MECKLENBURG COUNTY
Park and Recreation Department

MEMORANDUM

DATE: September 3, 2020

RE: Rezoning Petition #2020-035 – IBM Drive

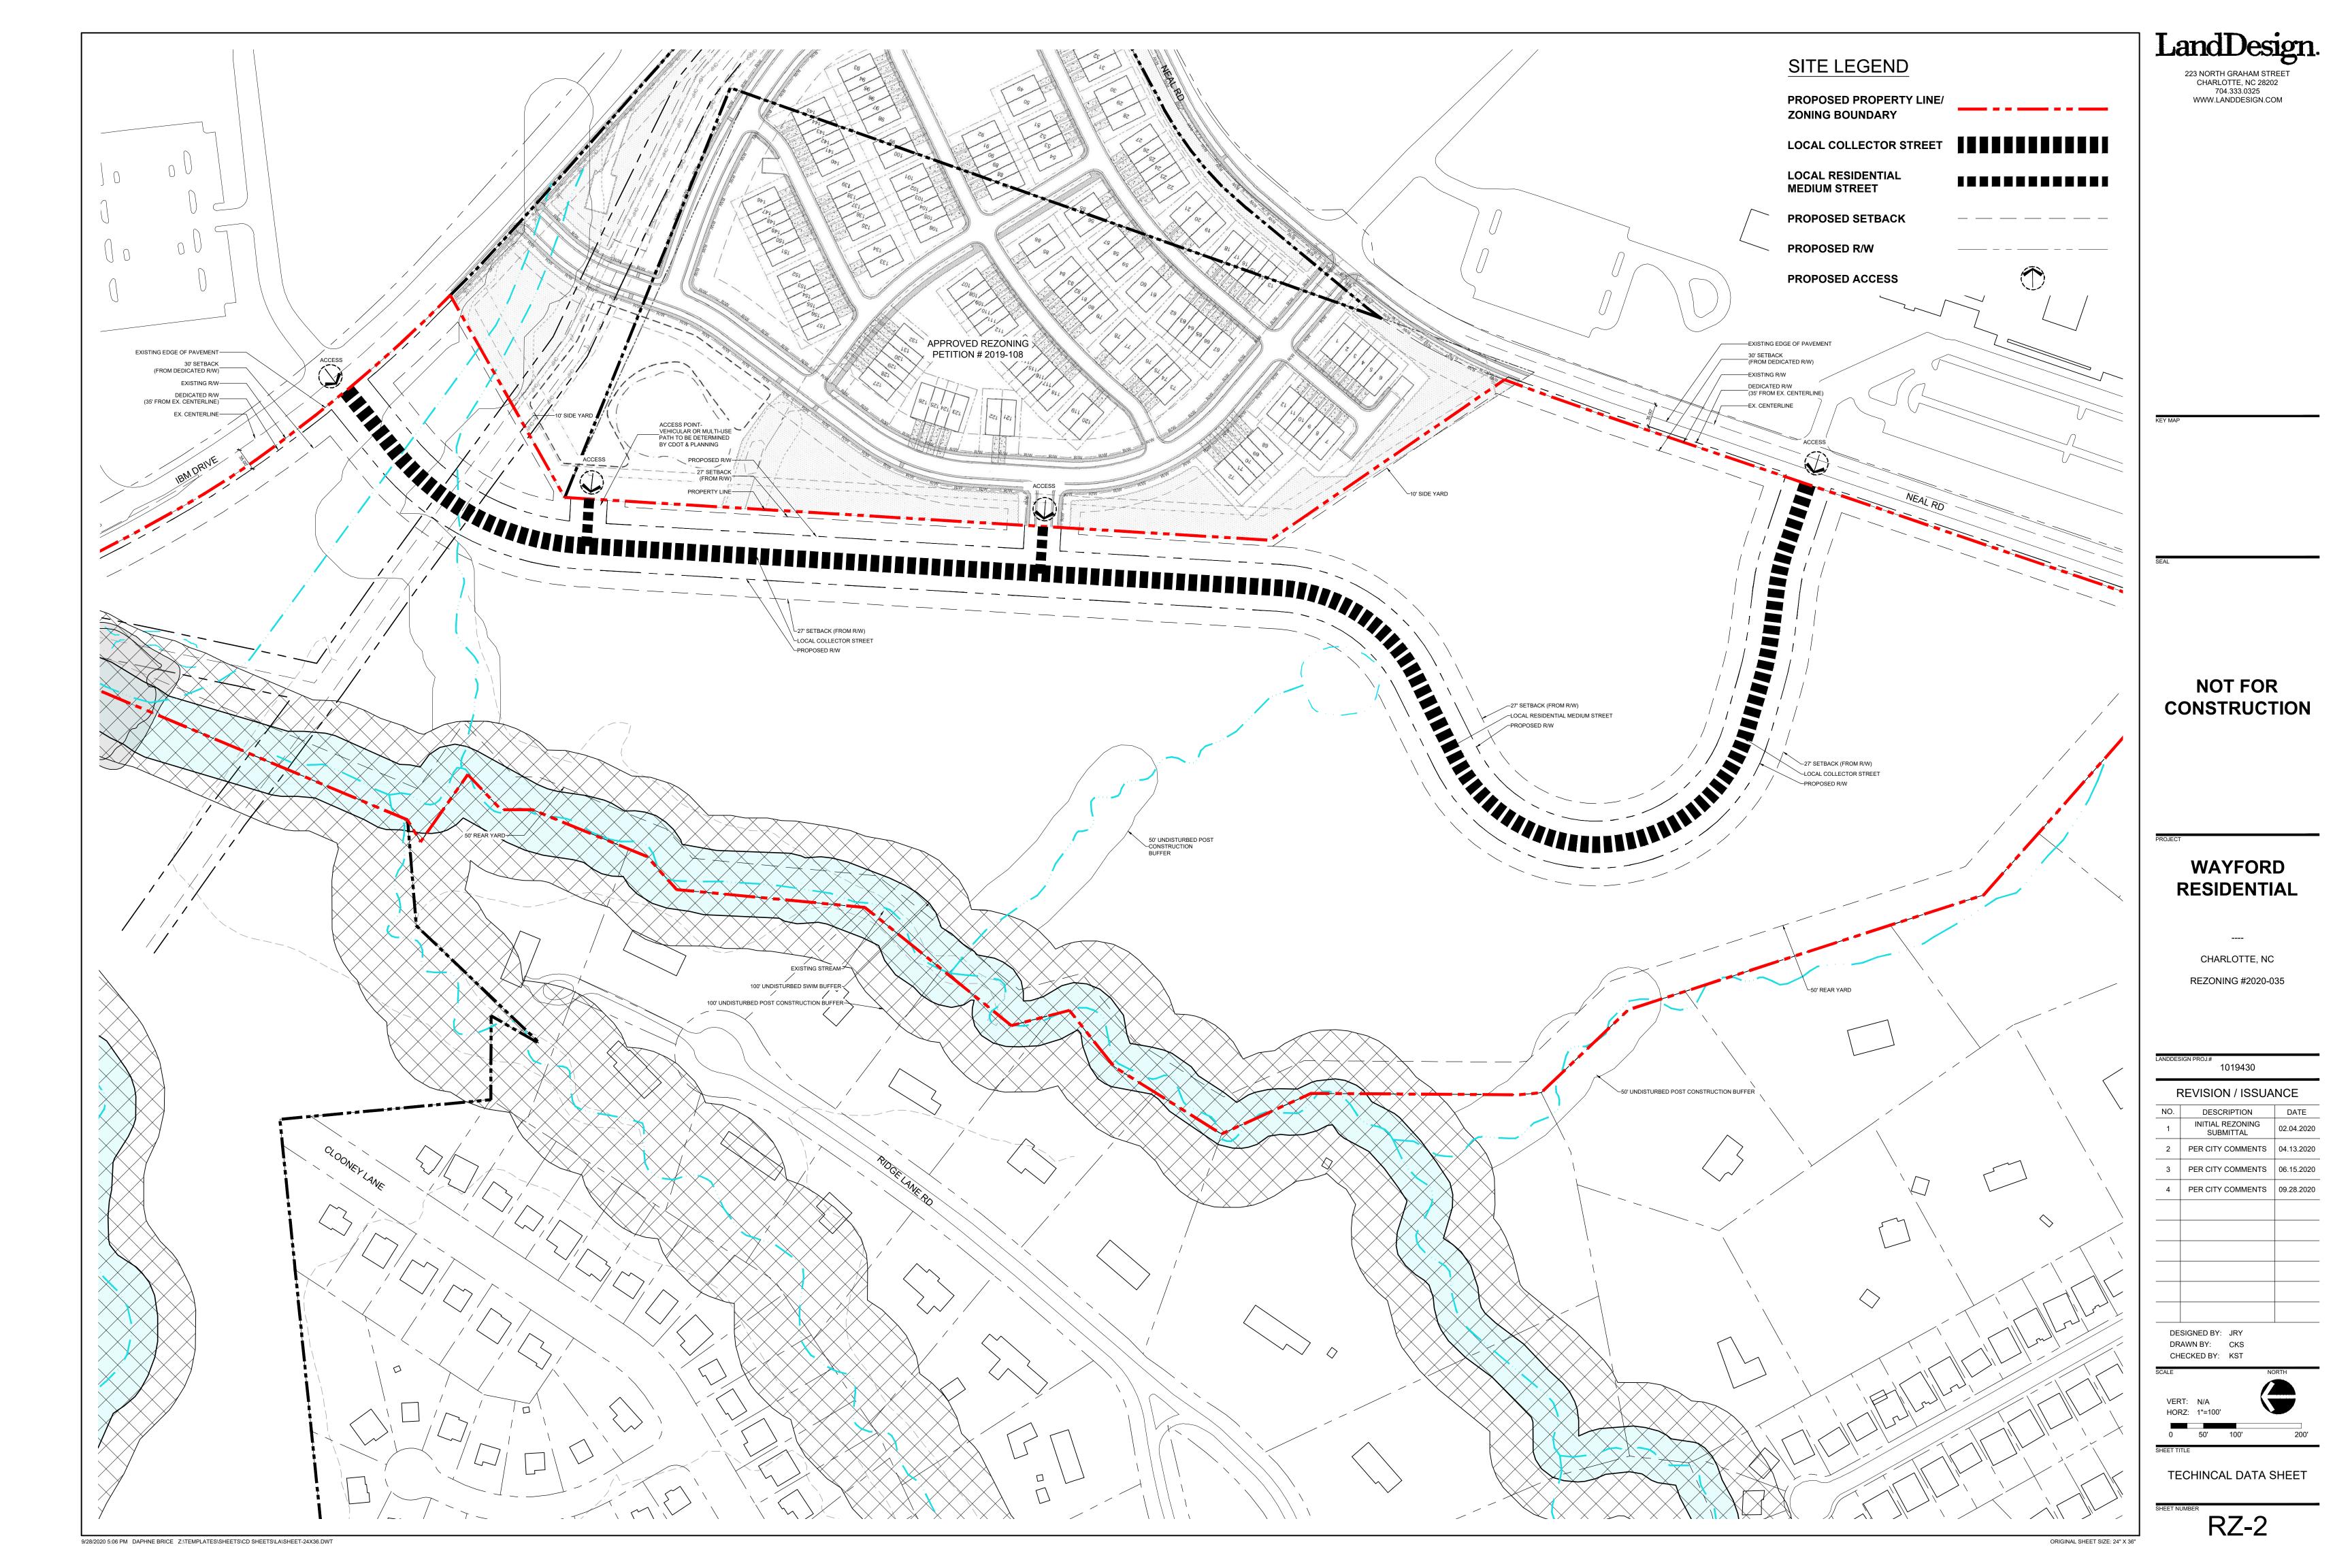
MCPR requests the petitioner consider dedicating and conveying to Mecklenburg County the minimum 1.12 acre "Amenity Area" for a public neighborhood park. This petition is in a gap area for public open space. We would be happy to discuss in further detail upon request.
